Application No: EP/133/21/HH
Site Address: 11 Worthing Road East Preston BN16 1AT
Description of works: Rear roof dormer extension including the installation of 2 x side windows and 3 x front velux rooflights

This Application was considered by this council's Planning & Licensing Committee on Monday, 8th November.

11 WORTHING ROAD, EAST PRESTON
Proposals 03
Oct 2021

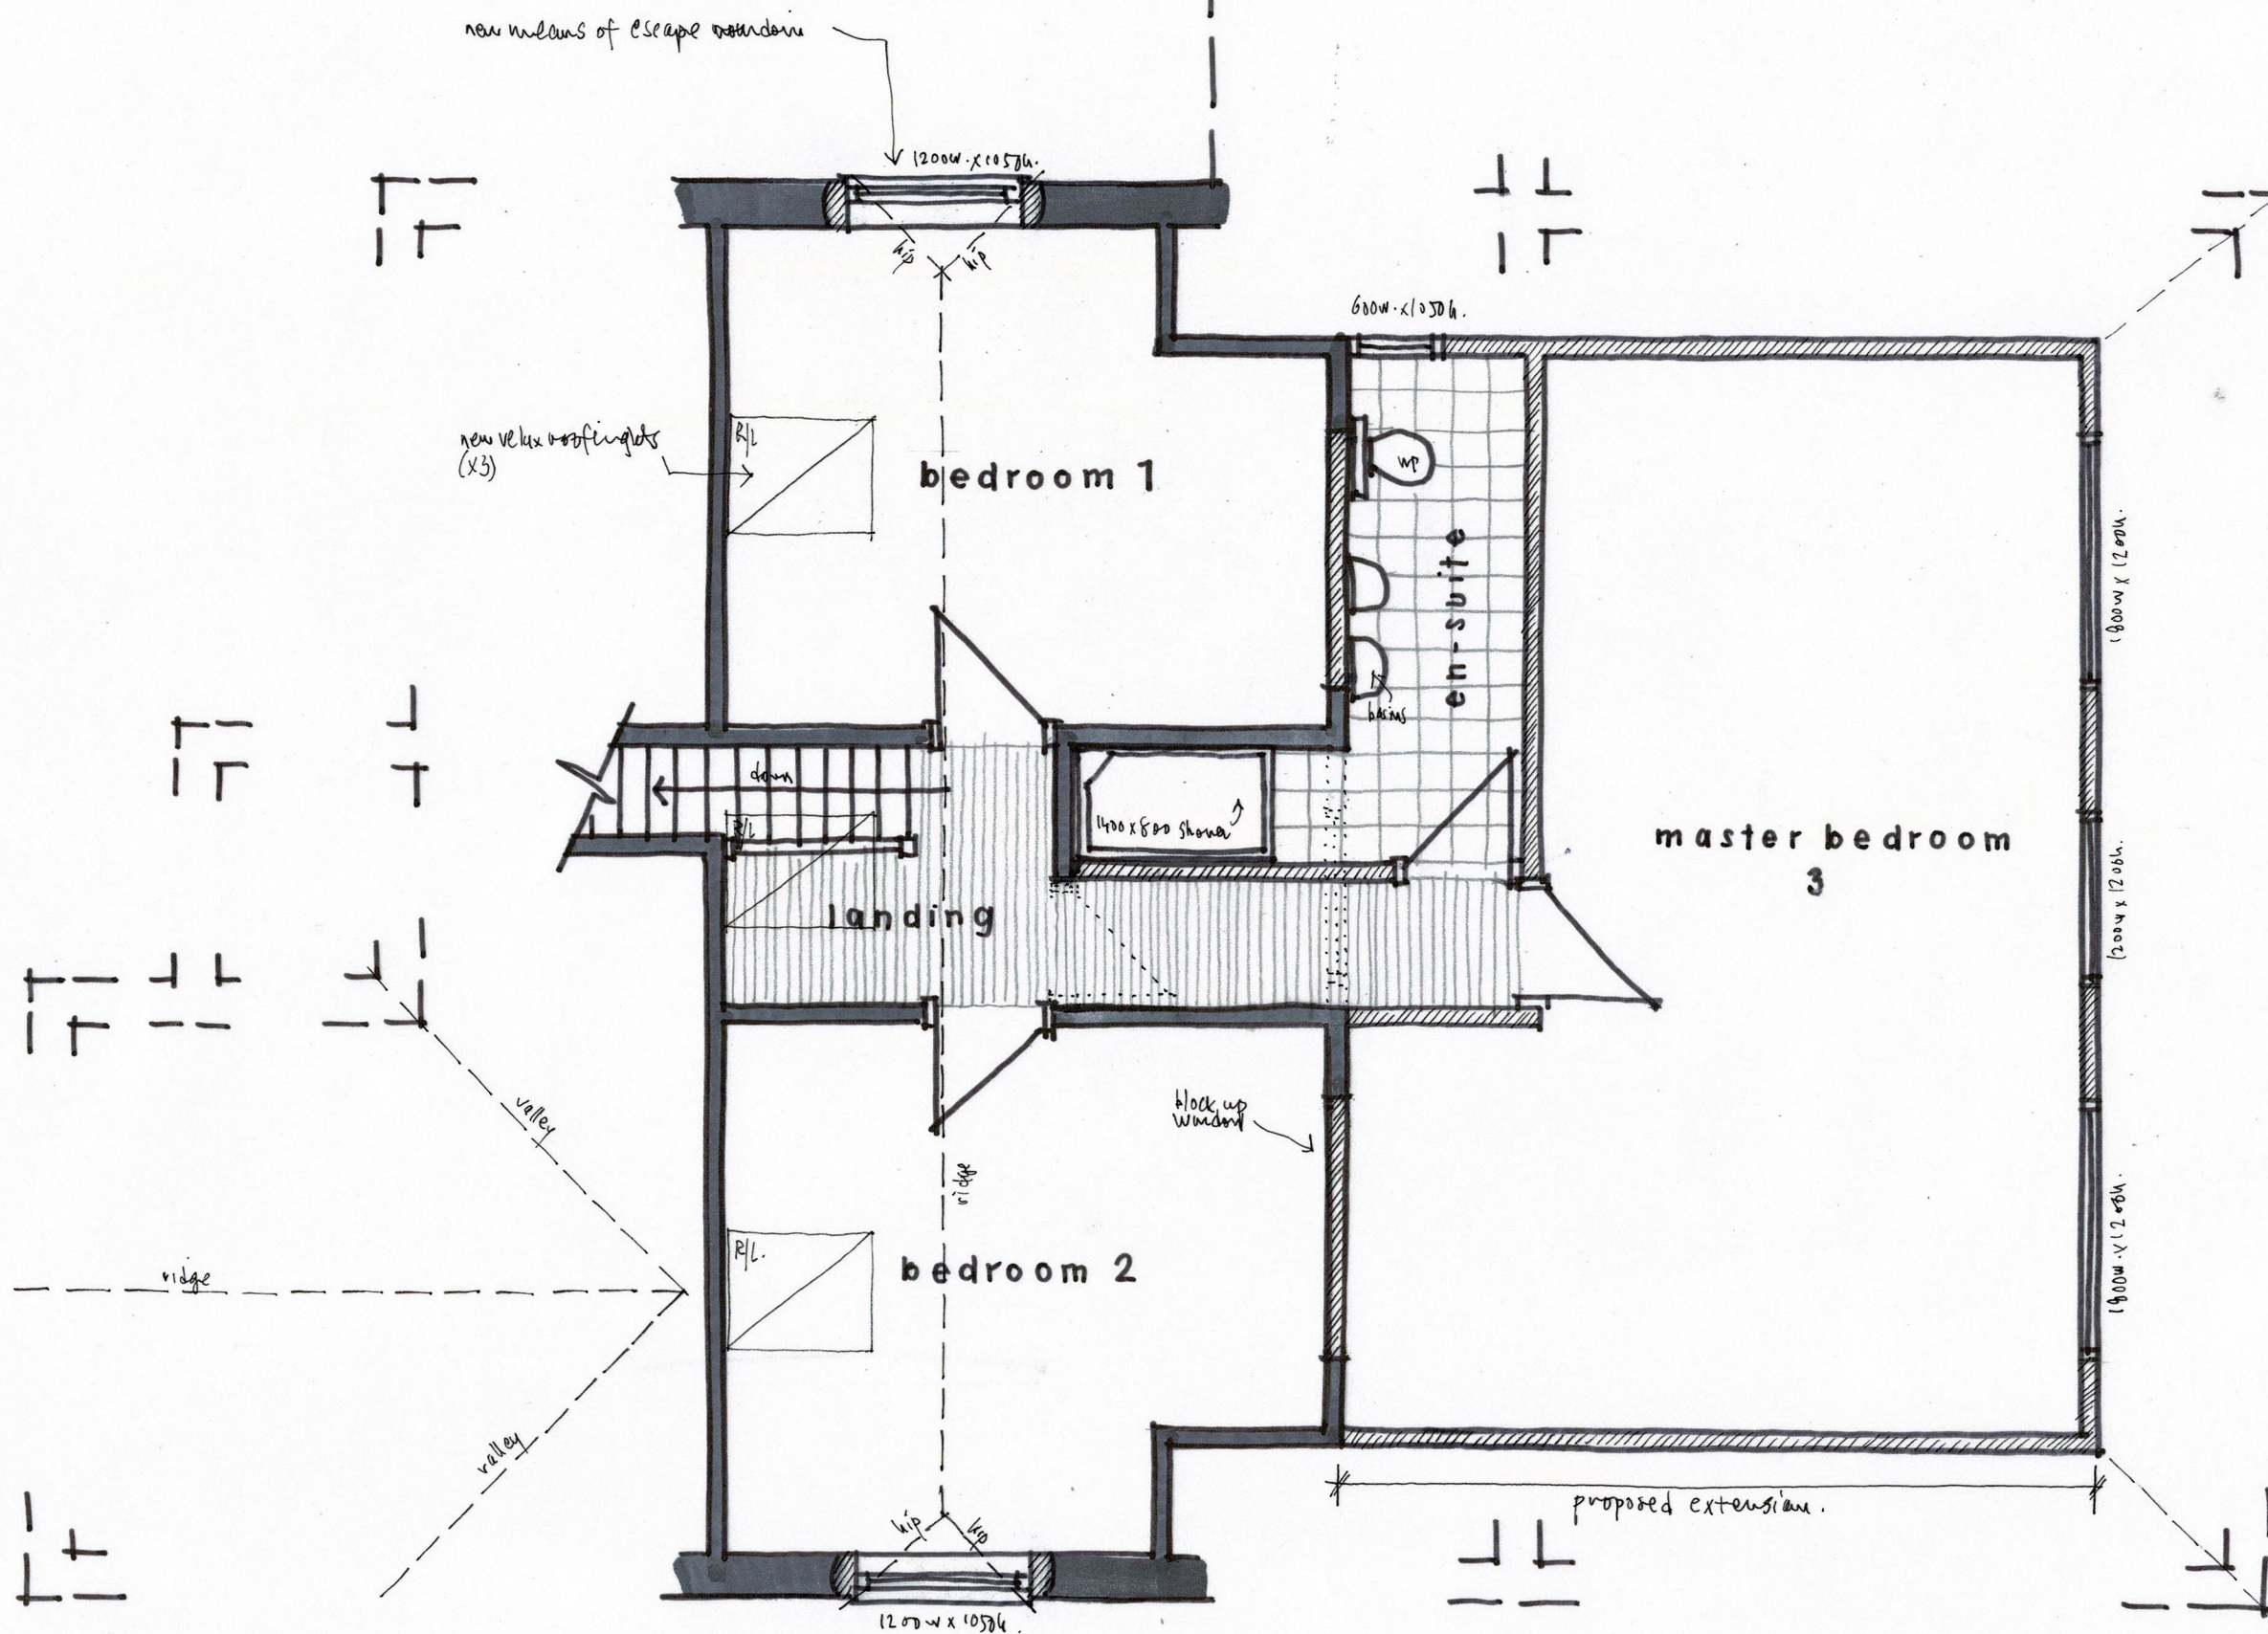
The committee agreed to object to this Application as it felt the proposed development was overdevelopment, would result in a bulky and overbearing rear dormer, not especially subservient to the existing roof, and the proposed front rooflights would not be in character with the streetscene. Only one of the nearby bungalows has a front dormer and none have rooflights.
